RE: Albuquerque School of Excellence – Remodel
13201 Lomas Blvd NE, Albuquerque, NM 87112
(J-22/D050)
Building Permit NO. 201691547

Final Certificate of Occupancy

**RE: Albuquerque School of Excellence
13201 Lomas Blvd NE
Grading and Drainage Plan
Engineers Stamp Date 6/28/16 (J22D050)**

From: Rael, Rudy E.
Sent: Tuesday, June 28, 2016 1:48 PM
To: 'Scott McGee (scottmmcgee@gmail.com)'
Cc: Abiel X. Carrillo
Subject: ABQ School of Excellence

By: WTB	Sheet: Of:
File:	TCI

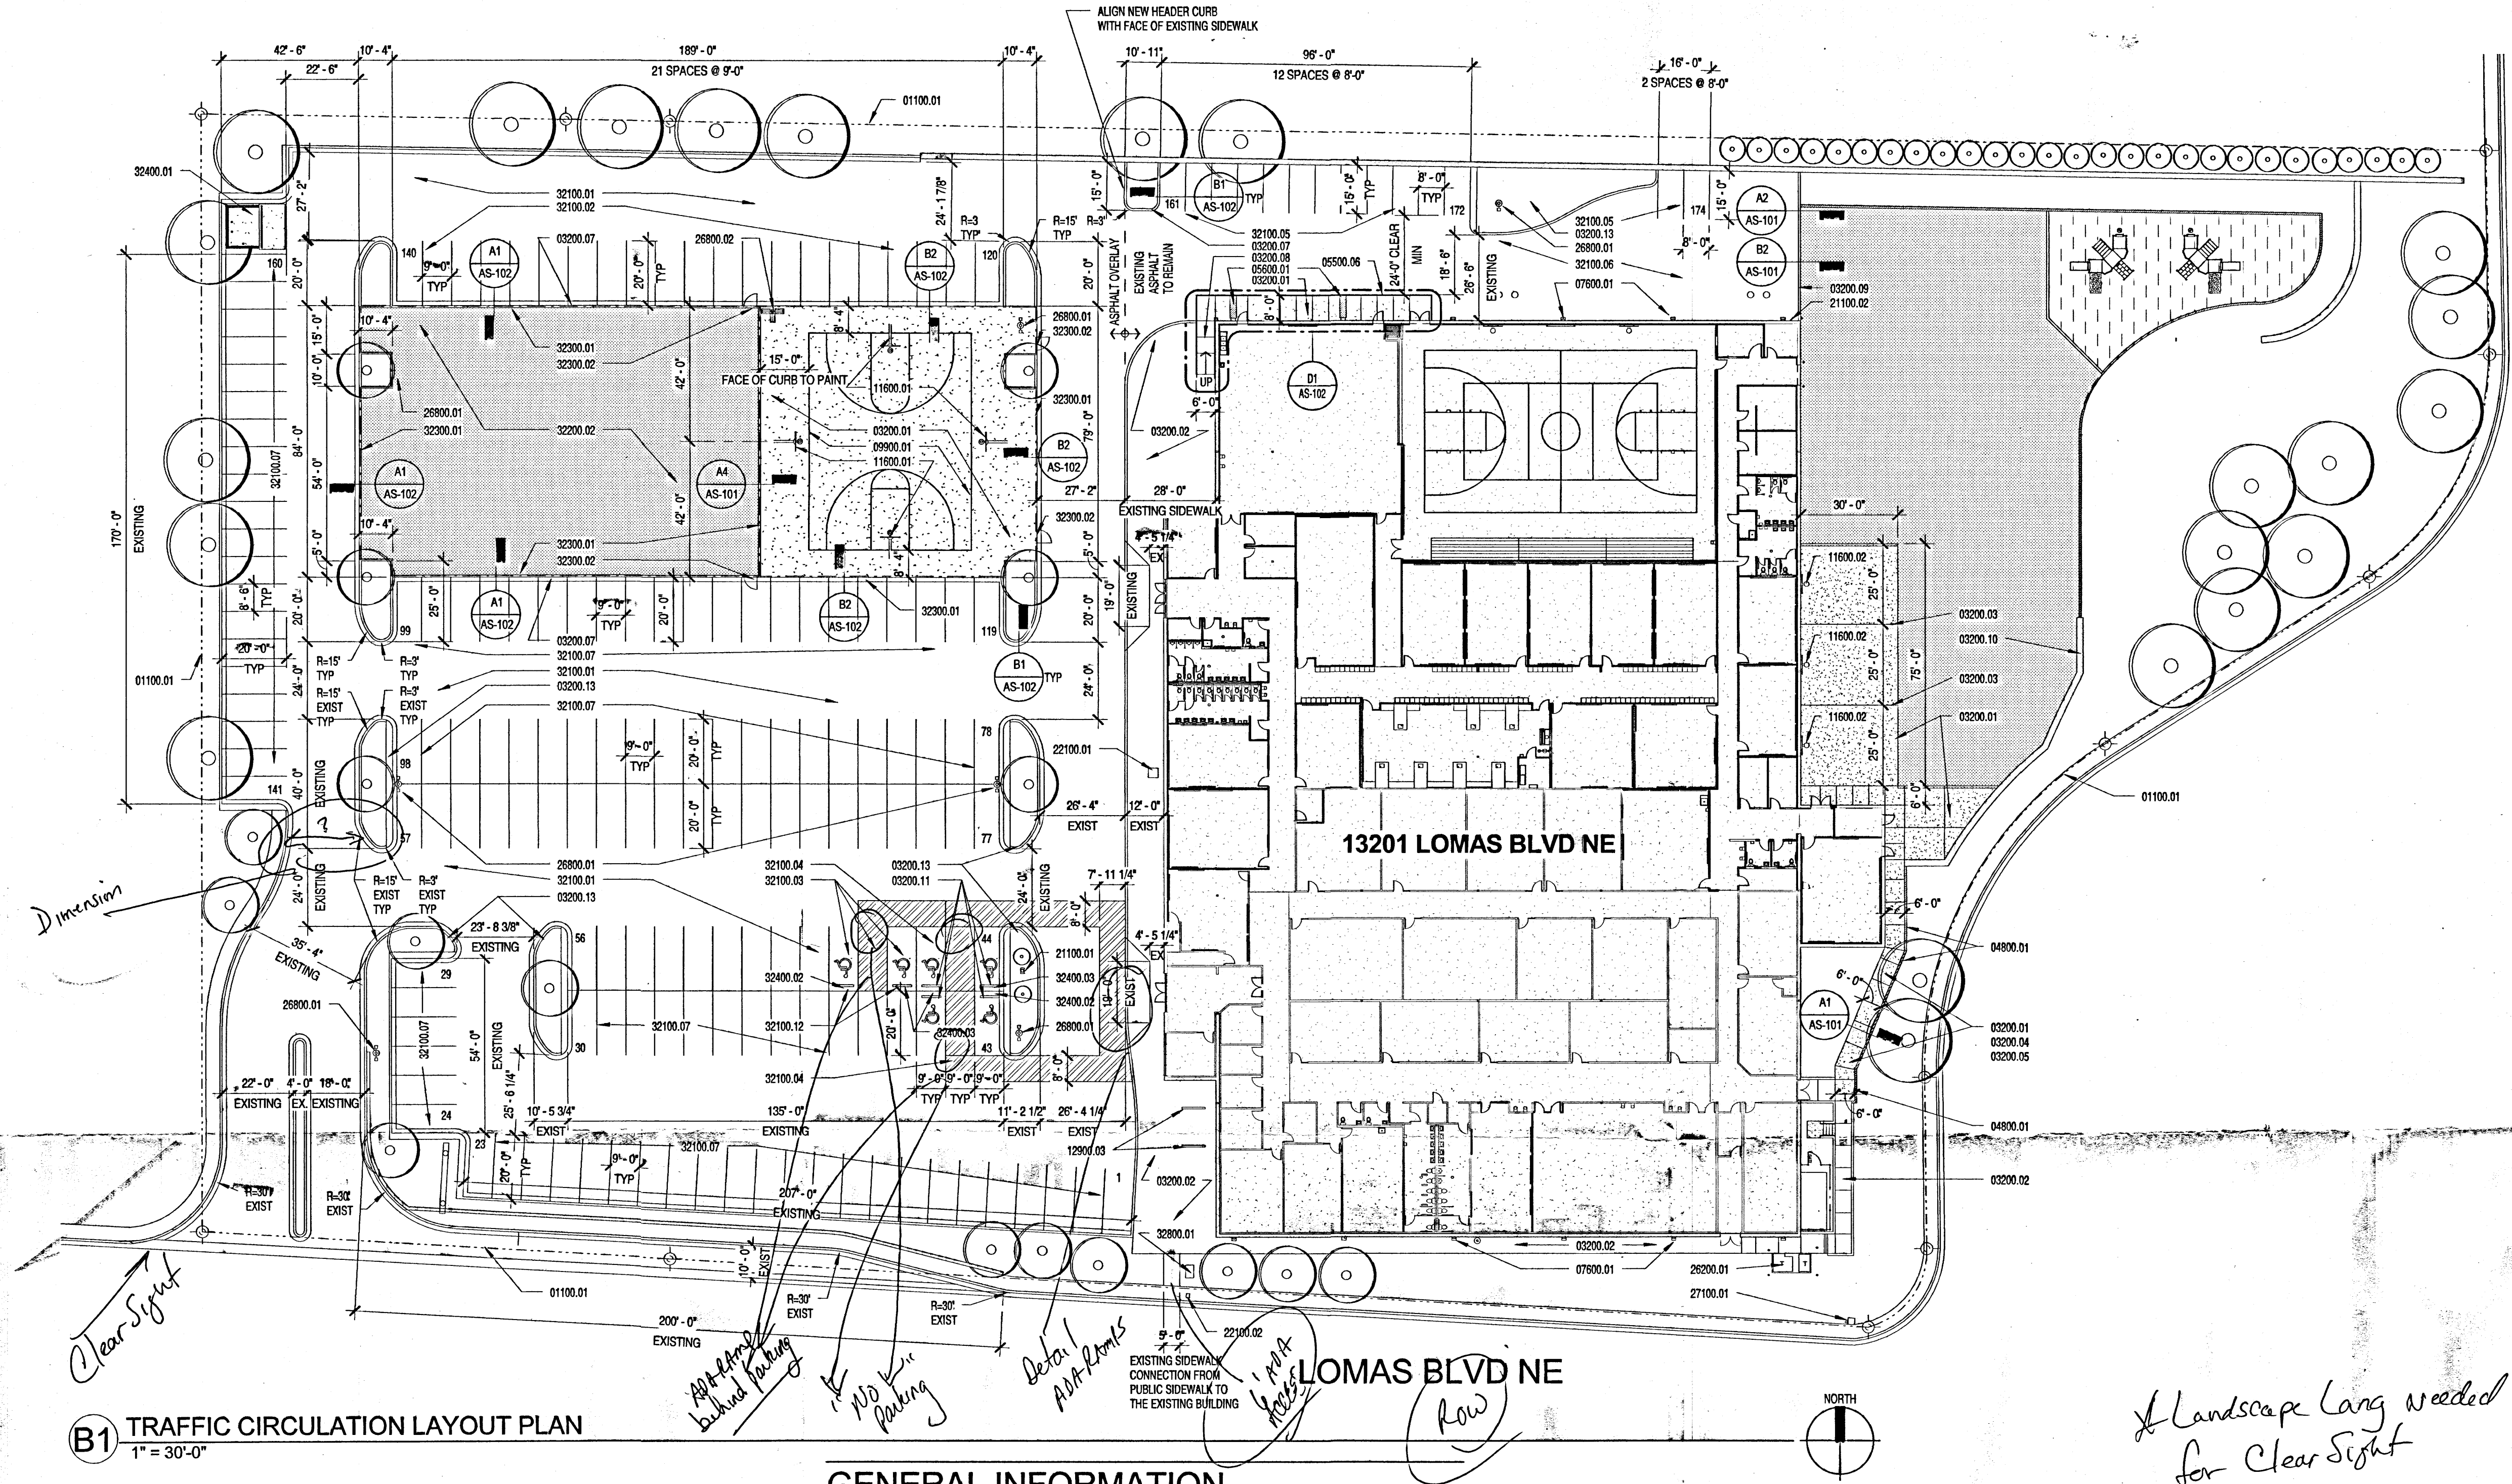
5. The handicap accessible spaces must be a minimum of 8.5 ft. in width.
6. The handicap accessible spaces must include an 8 ft. wide van access aisle; all other aisles should be 5 ft. in width.

7. The ADA accessible parking sign must have the required language per 66-7-352.4C NMSA 1978 **"Violators Are Subject to a Fine and/or Towing."** Please call out detail and location of HC signs.

9. Per DPM, a 6 ft. wide ADA accessible pedestrian pathway is required from the public sidewalk to the building entrances. Please clearly show this pathway and provide details. In review of the submitted drawing, the proposed ADA access from the ROW is 5 ft. in width.
